Your Ref: OWPC21210
Our Ref: FP/275/18/HH 21-12-2018
Please ask for:
Amber Willard

Double storey side/rear extension, remodelled roof and modified vehicular access and landscaping

20 Wedgwood Road Felpham

Objections to Flood Risk Assessment

MARKED UP TO SHOW PROPOSED
OFF-ROAD PARKING (cf exq
SINGLE SPACE)

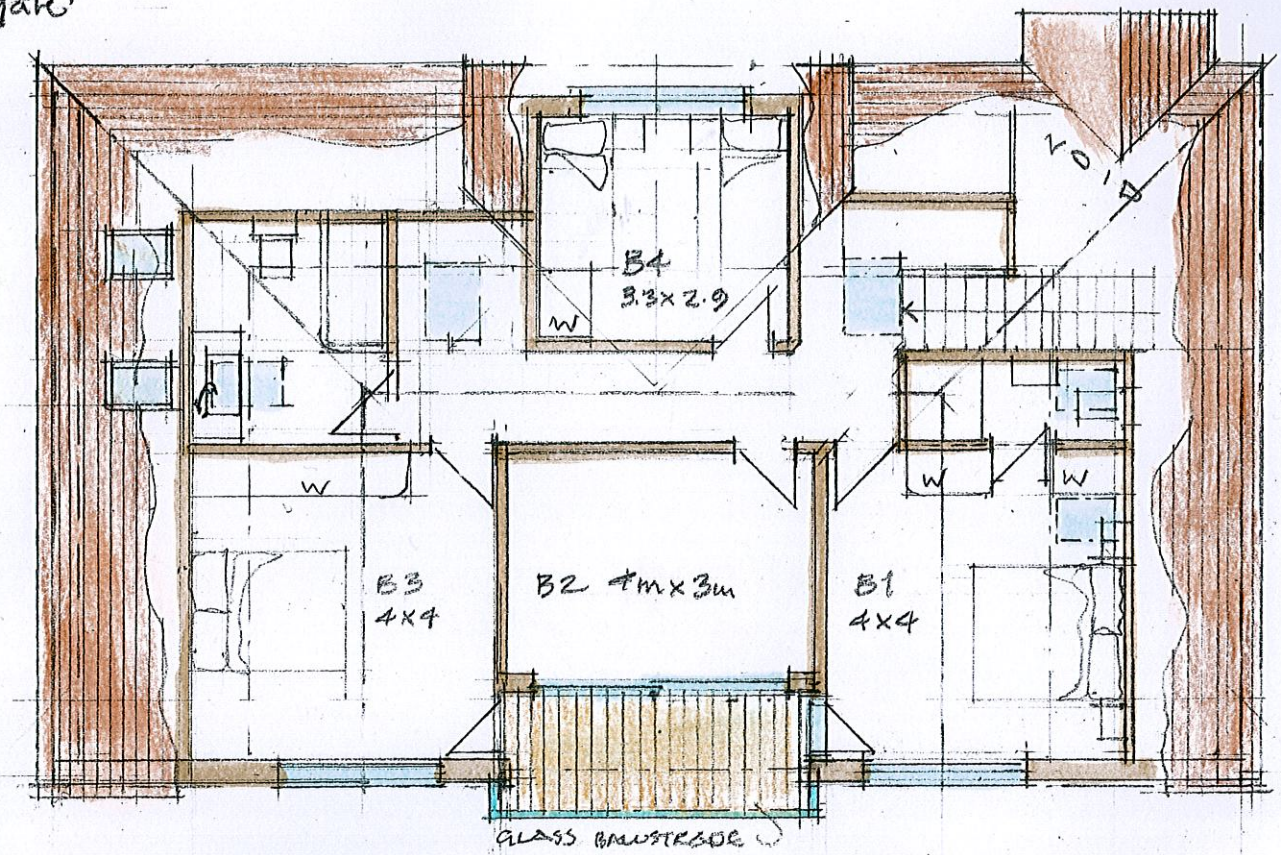
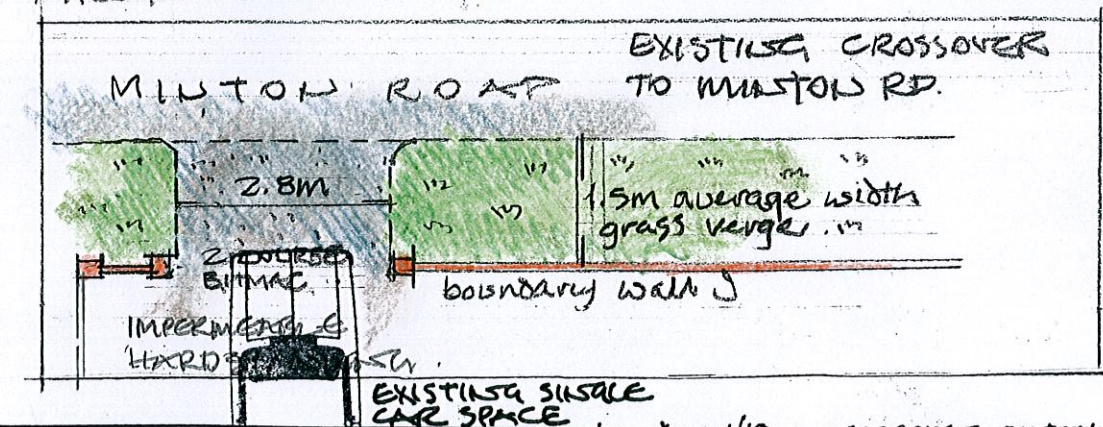
We have no objection to the extension of this property but we are concerned about the effects on drainage. Specifically our concerns are that the relocation of the driveway interferes with the soakaway installed in the grass verge outside the property in Minton Road and DOES therefore have an impact on flood defence management.

The proposed relocation of the driveway would cross over the top of this soakaway. We understand that the top of this soakaway is only approximately 300-450mm below the surface. We understand from a local builder that footings for a driveway would need to be deeper than this which would inevitably interfere with this soakaway. It is not as far as we are aware possible to relocate this soakaway as its current position is the result of discussions on site with Arun District Council and West Sussex County Council and the location was chosen to intercept the main flow of surface water runoff - which is that cascading down from the higher part of Minton Road. There is a corresponding soakaway on the northern side of Minton Road.

RELOCATE CROSSOVER
SPECIFICATION OF MAKE UP &
SURFACE TO BE AGREED

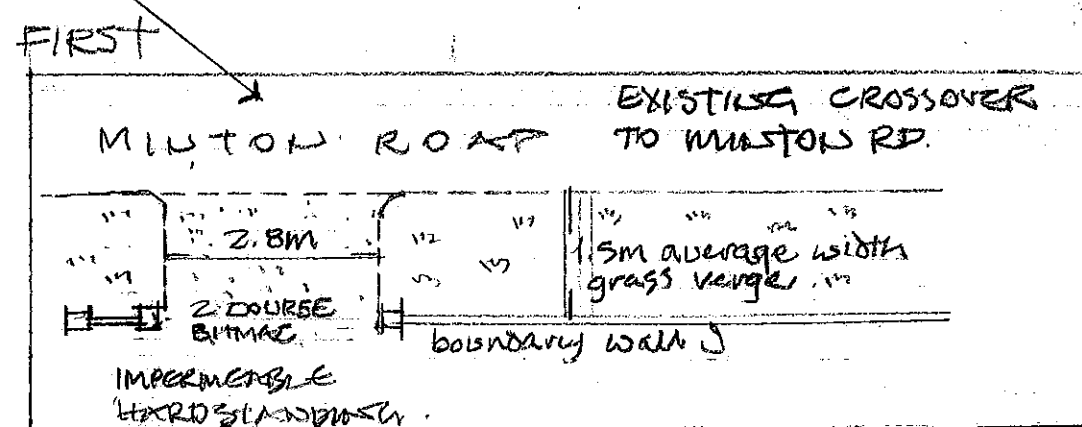
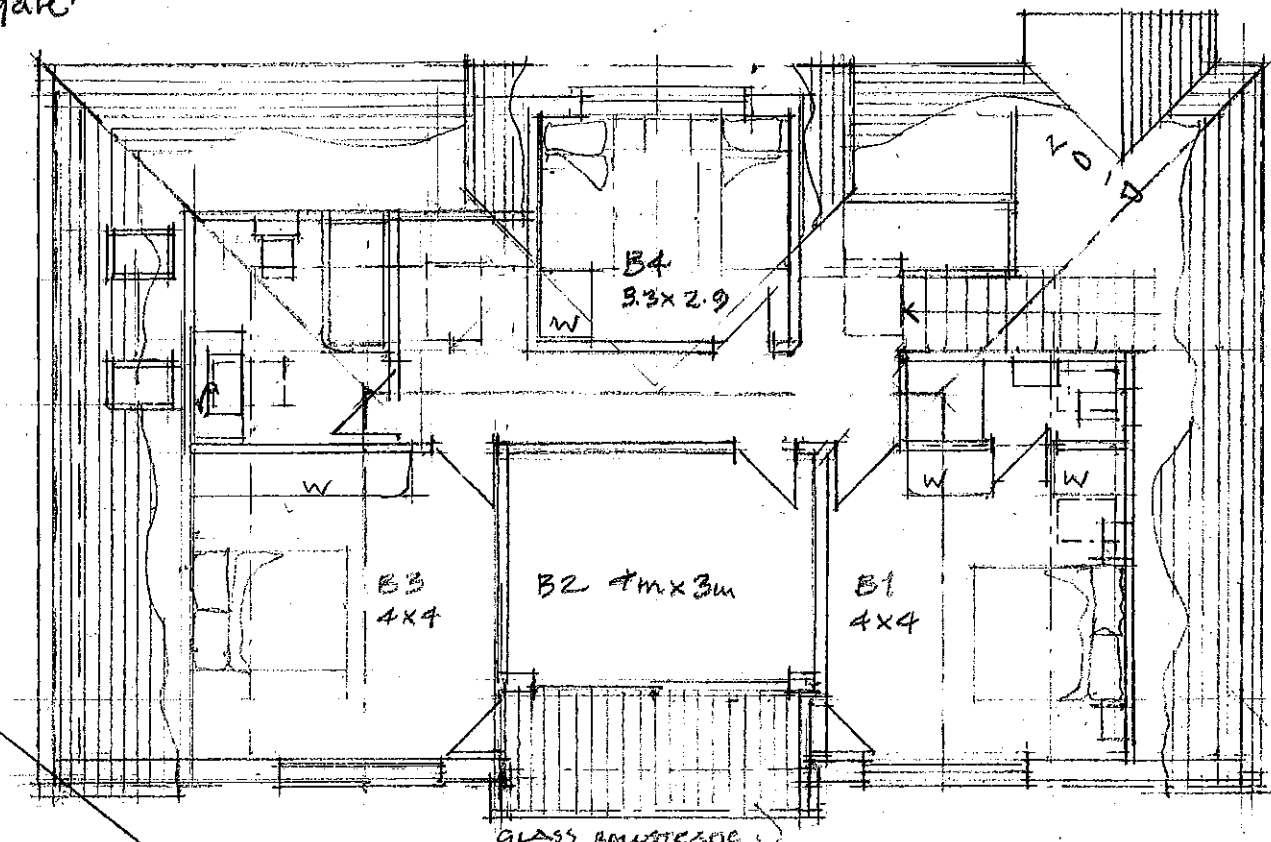
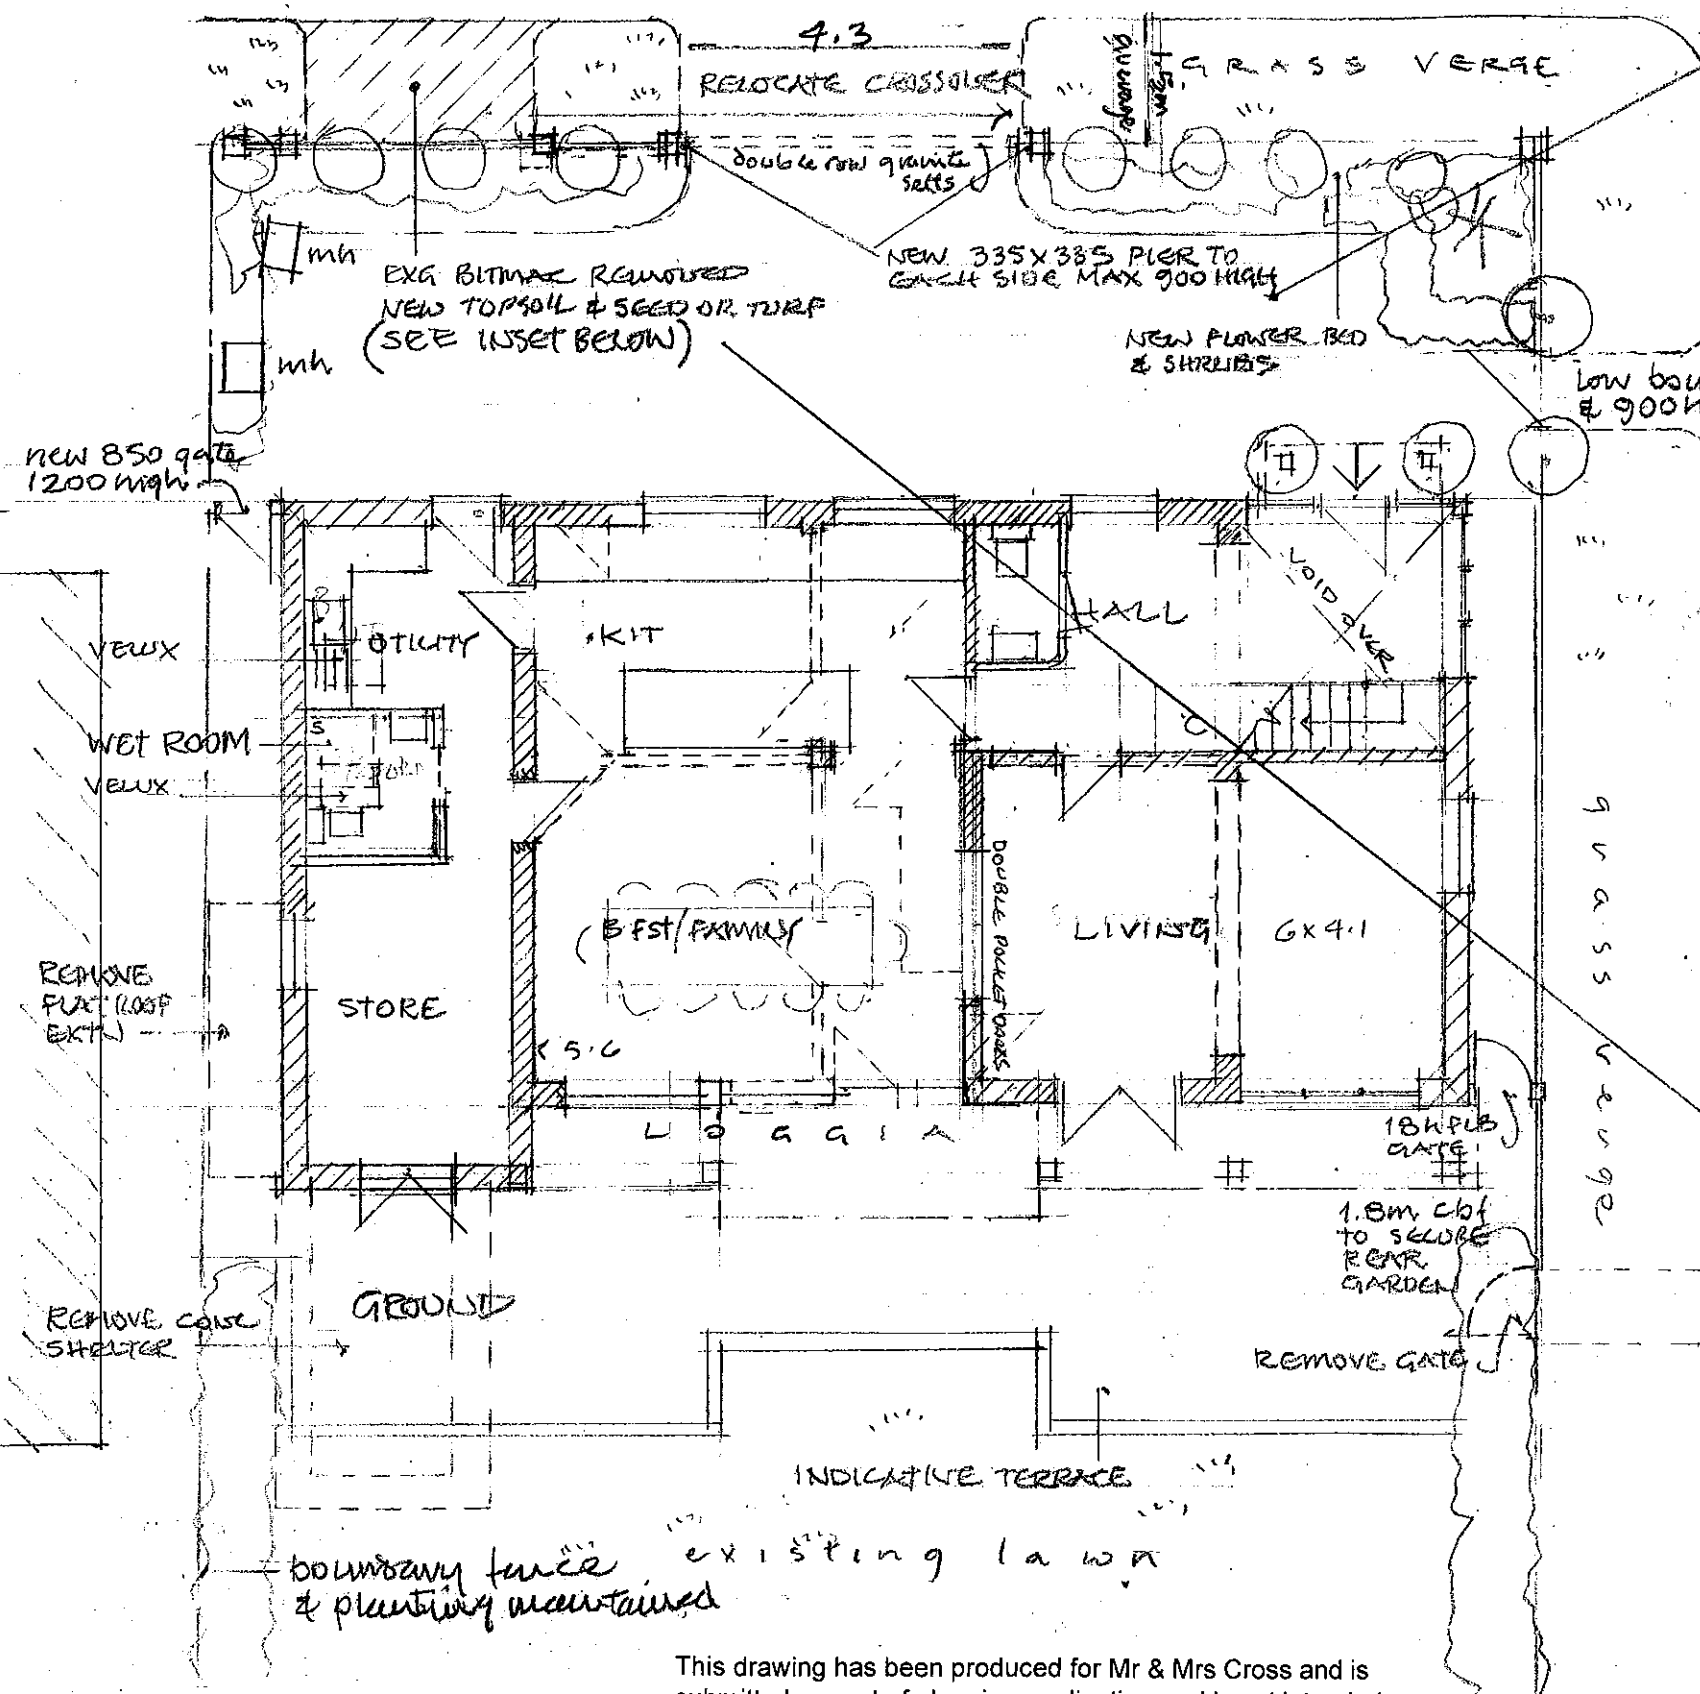
We are also concerned that the ante-penultimate paragraph of this assessment expresses no more than a hope that no additional surface water will be discharged beyond the site curtilage. In view of the extreme flooding suffered in 2012, of which Arun District Council will of course be very much aware, this seems to be insufficiently defined in terms of the actions that will be taken to ensure this hope is realised.
